April 24, 2023

**RE: Undi Commerce Park**

The responses below correlate to the numbered review comments on your letter dated April 27, 2022.

ENCLOSURE PLAN AT (BLDGS I, J, K ONLY)

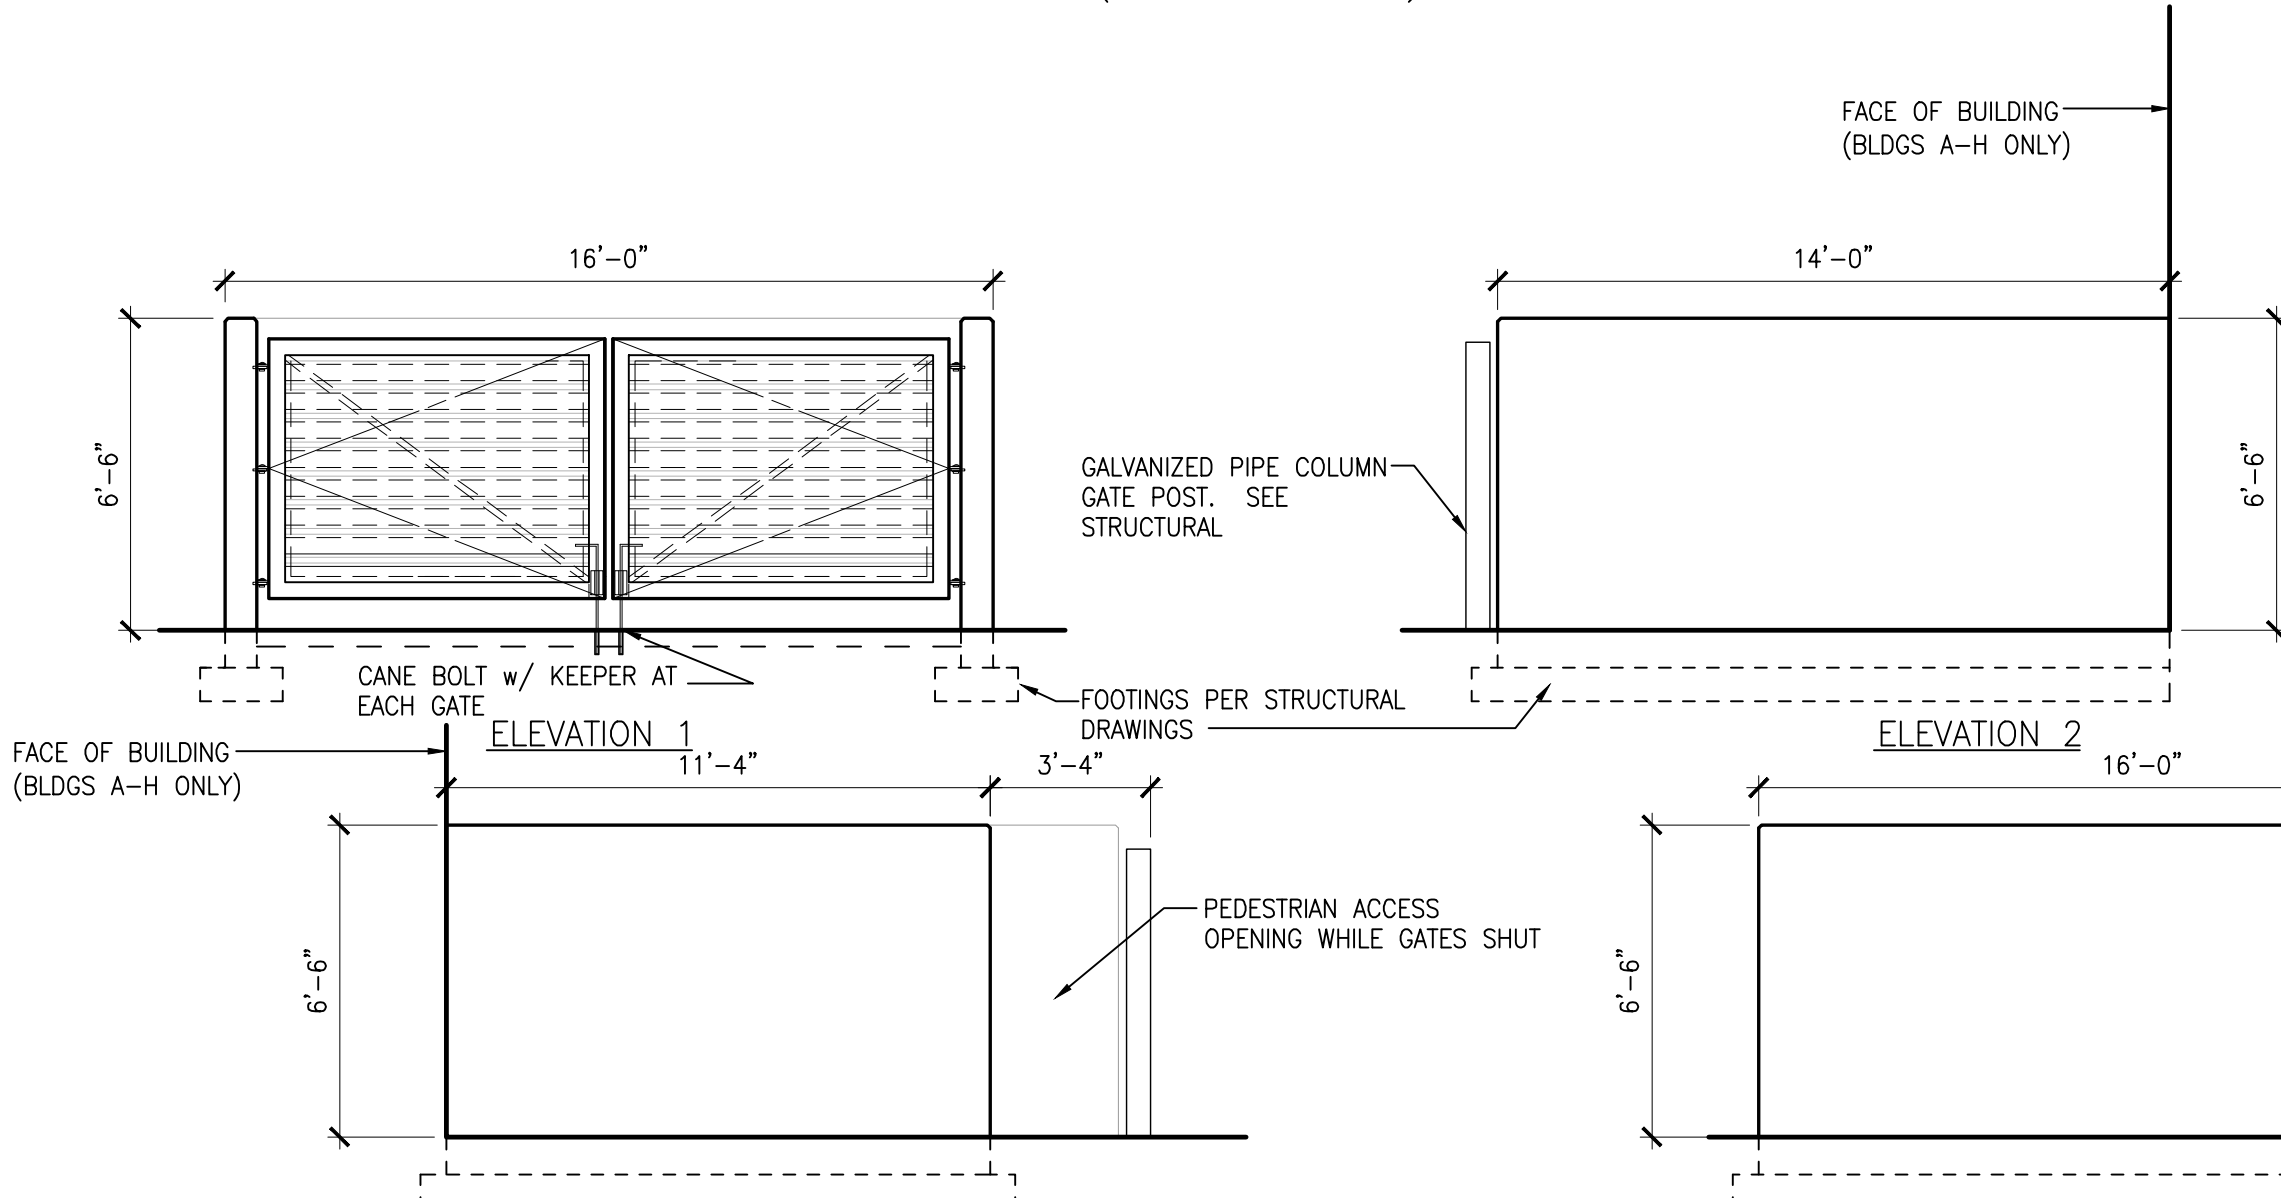
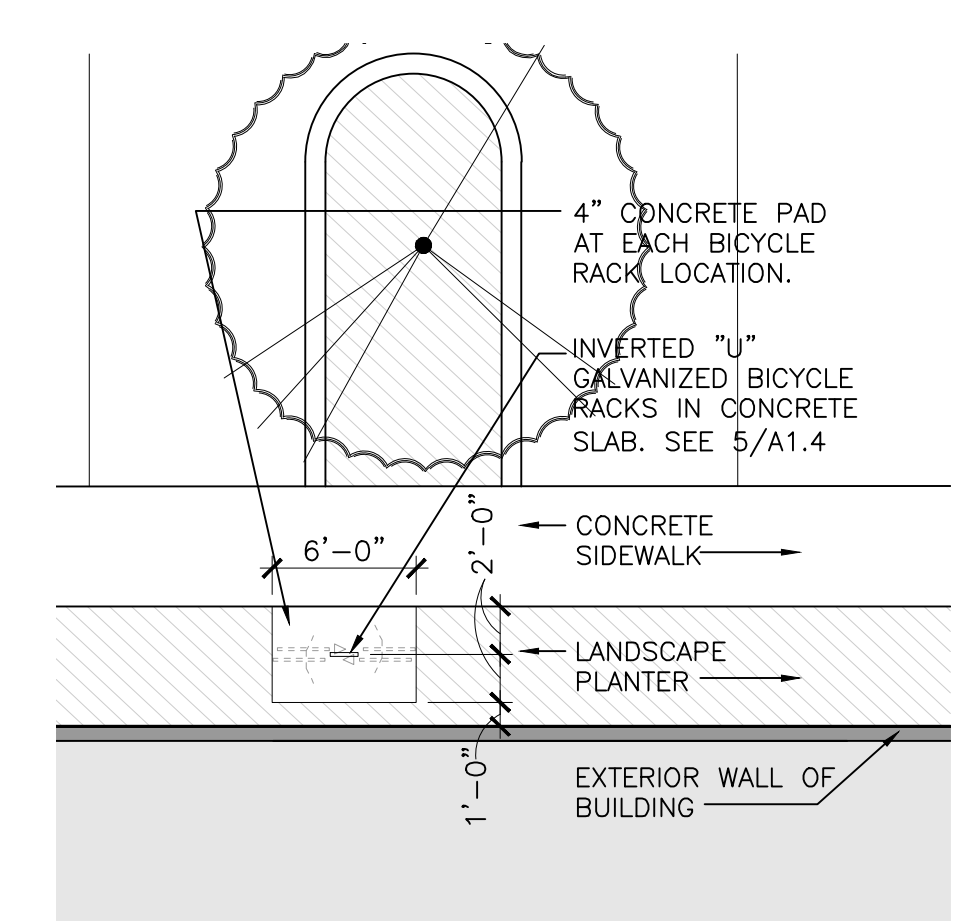
- 5c. Trash/recycle enclosures have been added to the site plans as requested. Required SF calculations are shown on each building. Provided SF is greater than required for all buildings. Landscaping has been provided around each and all enclosures are shielded from city streets and neighboring properties by perimeter landscaping. Enclosure walls are concrete complementary to the buildings. Details for enclosure, gates and wall elevations are shown on sheet A1.4.

9 CARPOOL DESIGNATION AND SIGNAGE
Scale: 1/8"=1'-0"

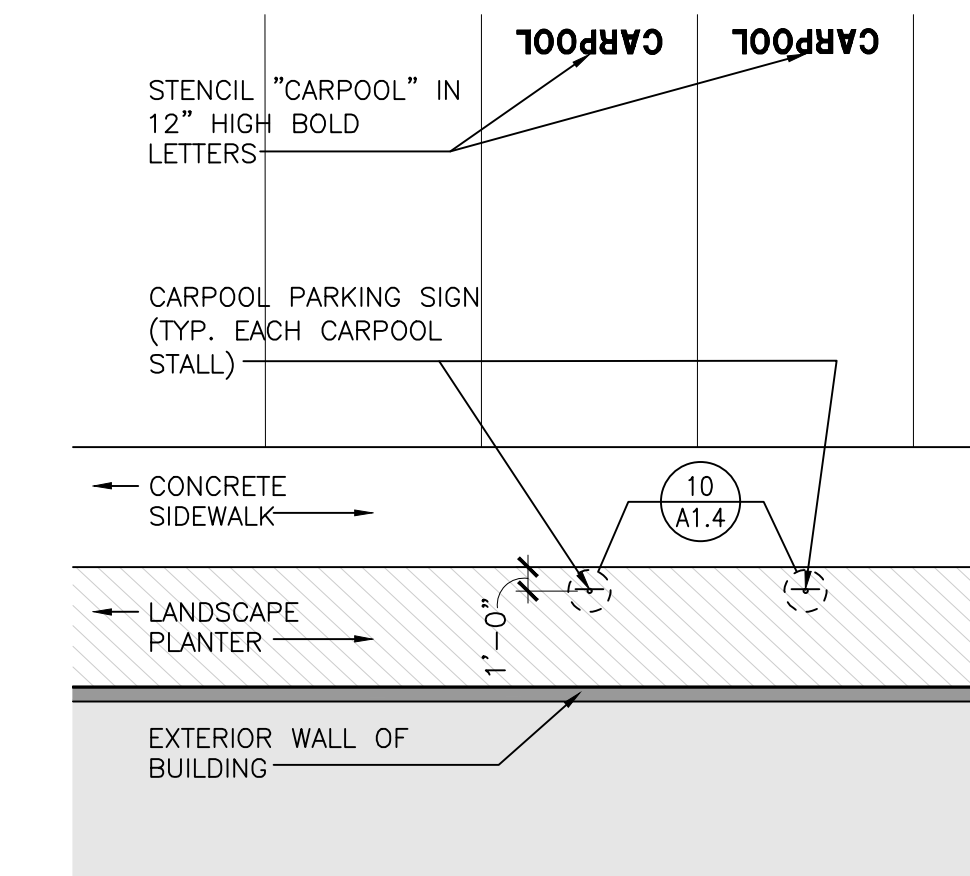
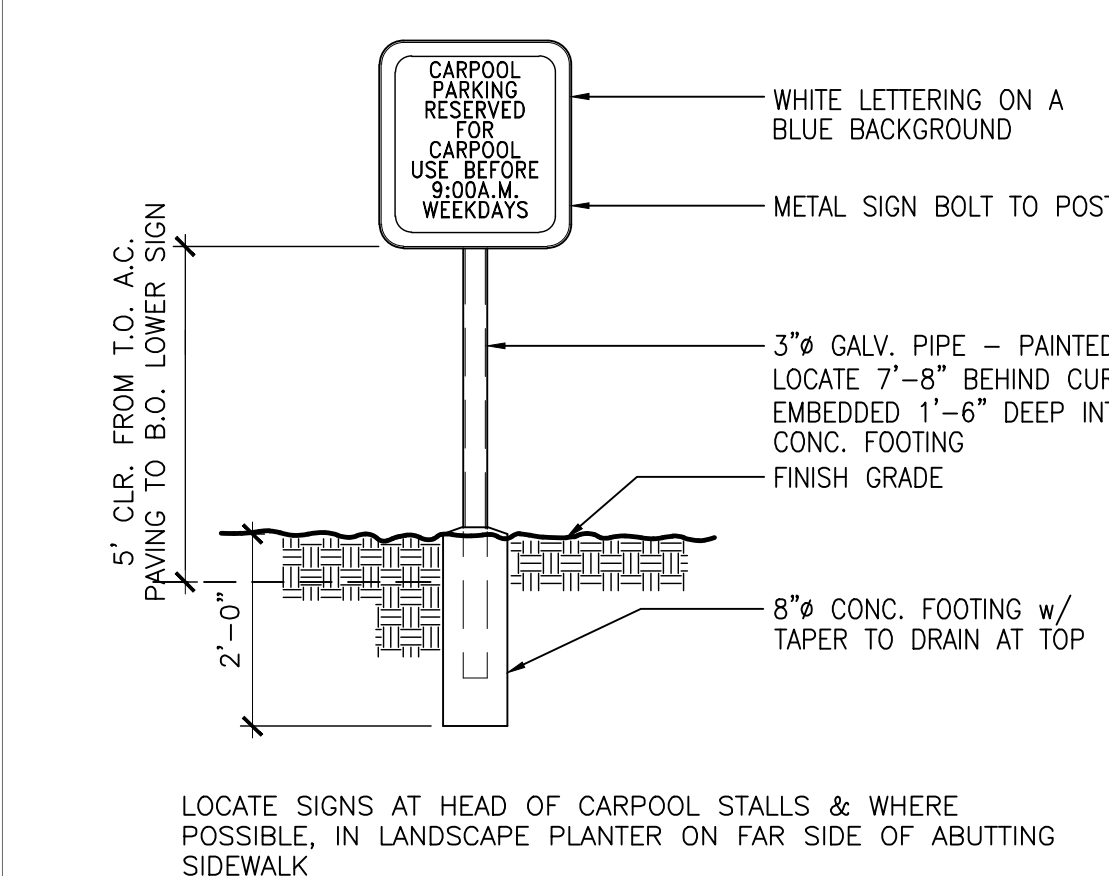
- 5i. Carpool parking signage will be provided at all carpool parking depicted. A detail of the sign and typical parking space is shown on sheet A1.4.
- 5j. Bicycle parking calculations have been provided on sheet A1.1 under Site Information. Bicycle parking locations have been added around all buildings as required by MMC 22C.130.060. The bicycle parking provided is greater than required for all buildings.
- 5k. Marysville specific notes have been added to sheet A1.1 under MARYSVILLE NOTES.
6. Preliminary landscape plans will be provided as part of site plan review at a later date. The plans will comply with the conditions listed in MMC 22C.120.
7. Illumination plans will be provided as part of site plan review prior to civil construction plan review. The plans will comply with the conditions listed in MMC 22C.130.050(3)(d).

SHEET **C3** of **C13**  
24x36  
PA22-008  
G2

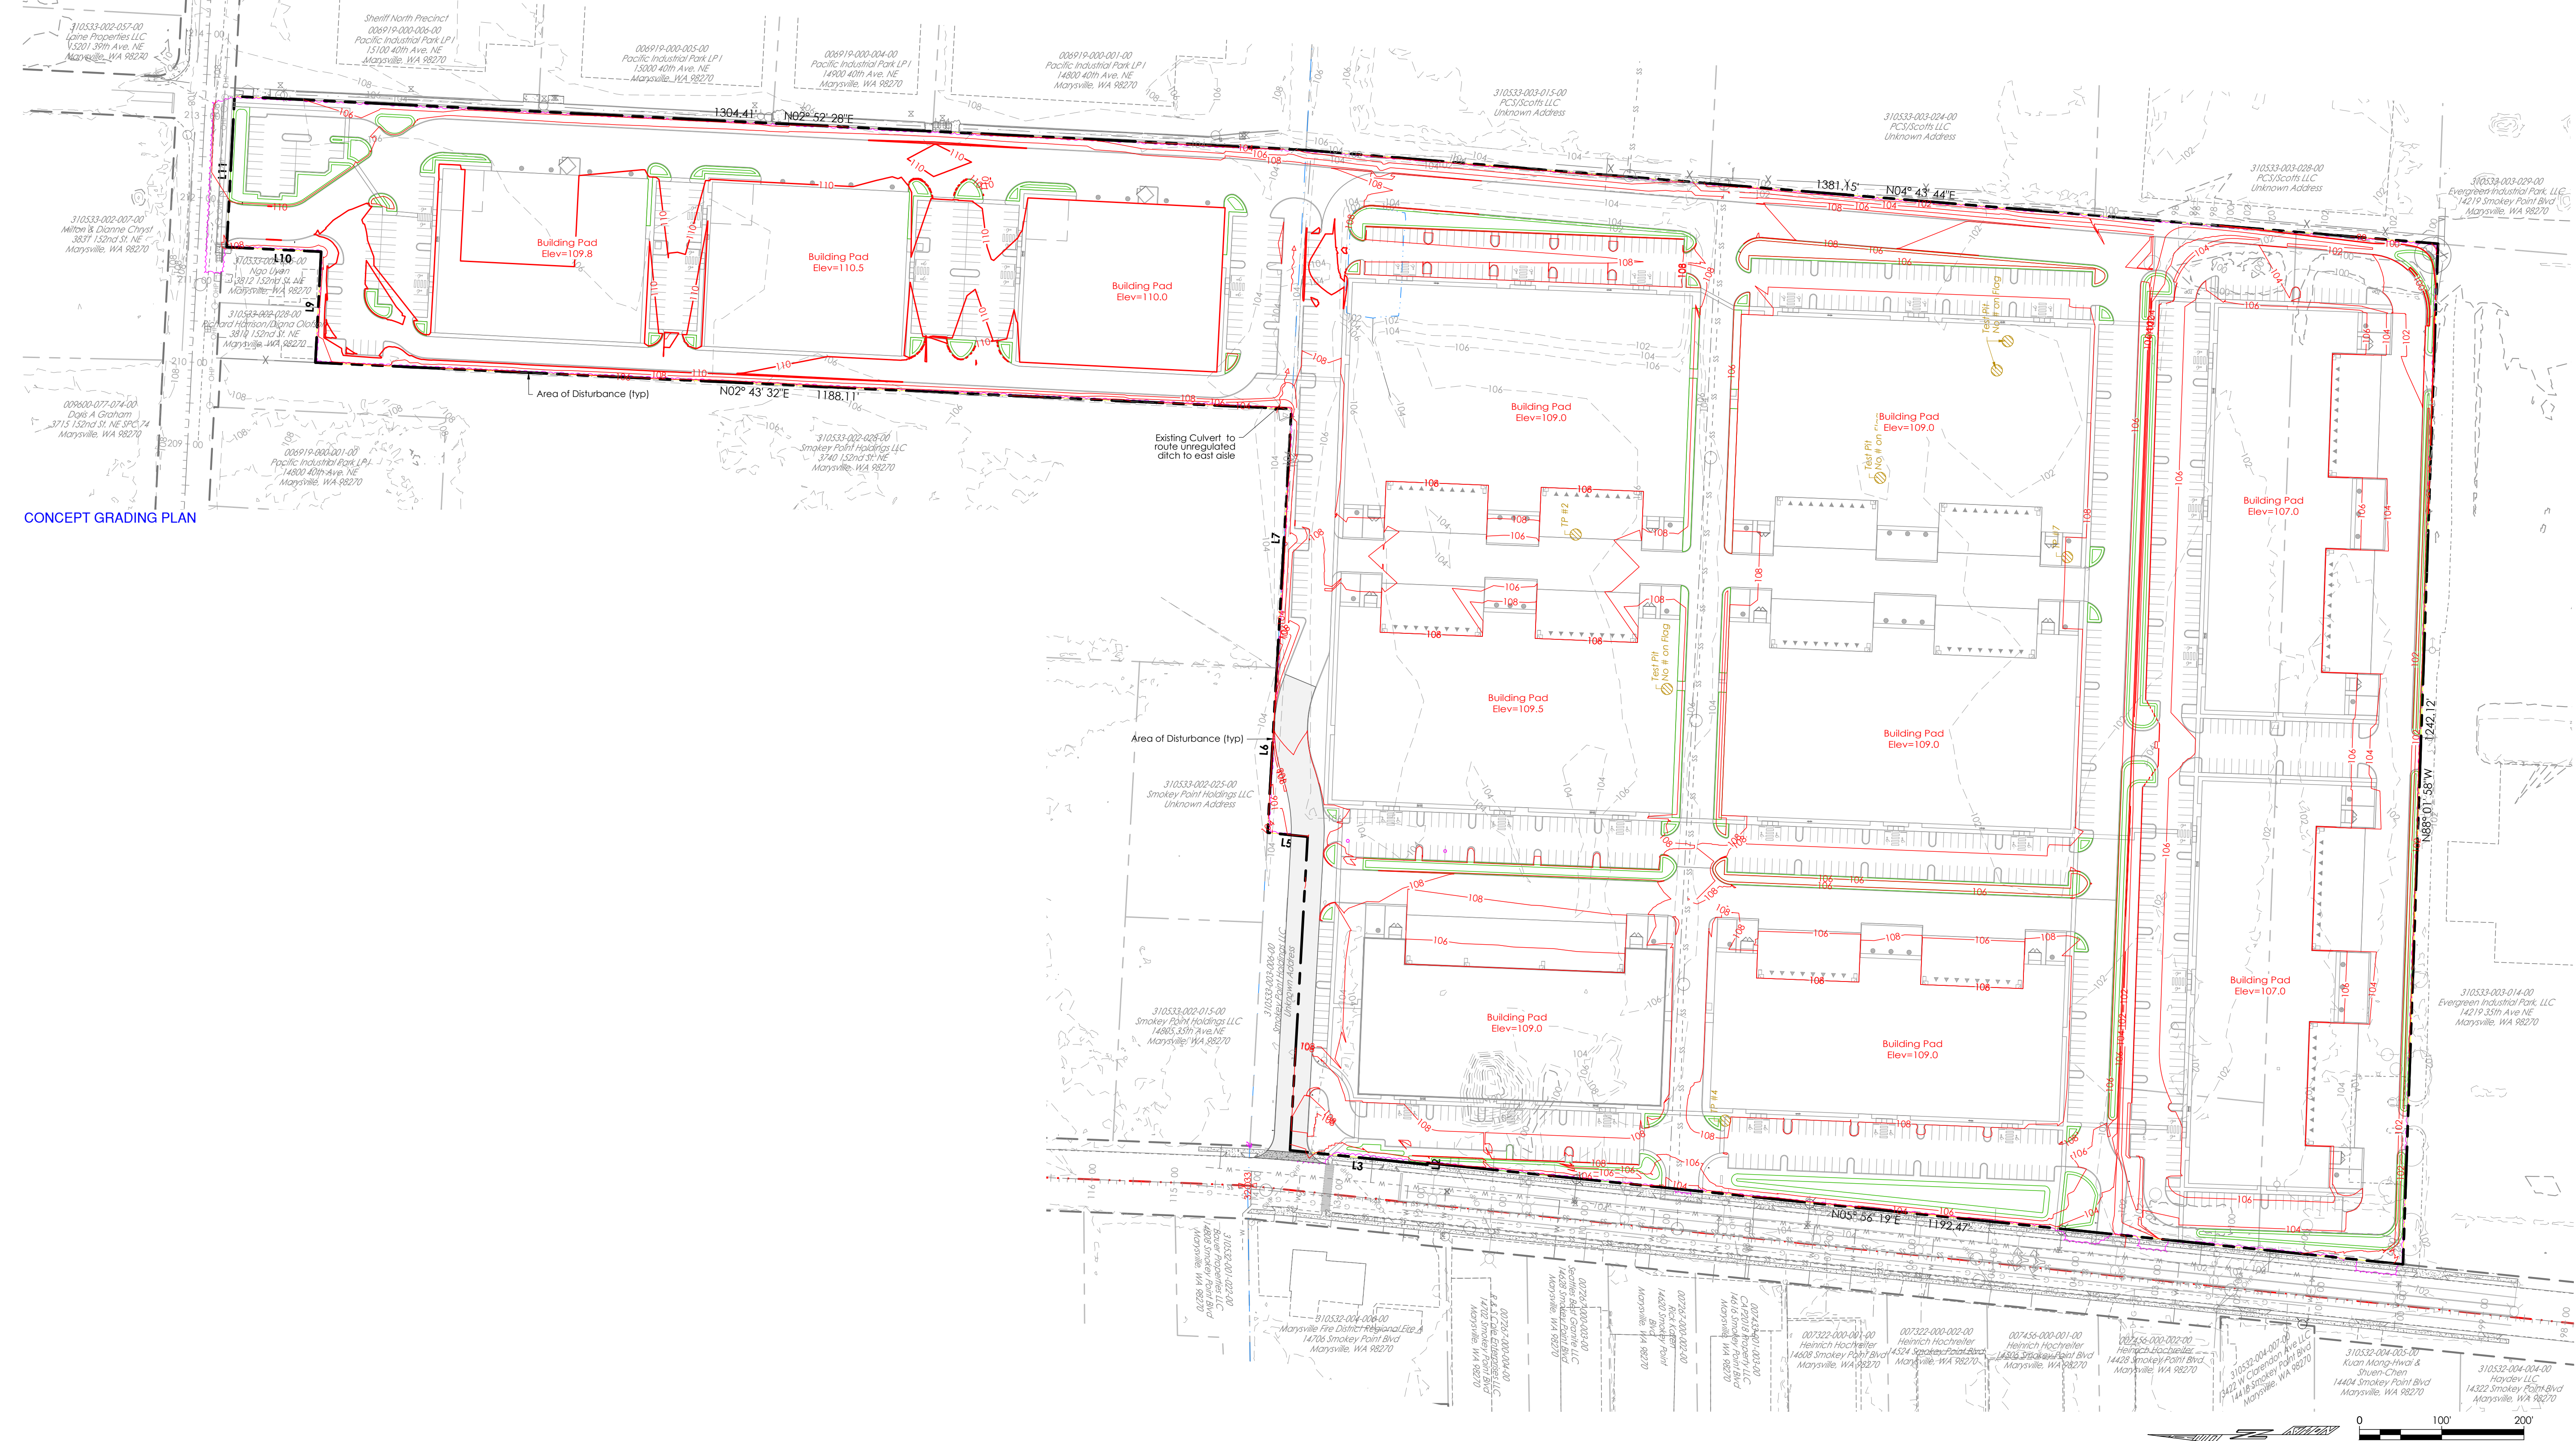
3. Existing conditions are shown on Civil sheet C3.
4. We are currently in the process of negotiating an easement (between UCP and APM 31053300302400) with the adjacent property owner (PCS-Scotts LLC) and his lender, regarding the structure of the easement. We will provide the easement agreement upon signing it (expected end of May 2023).
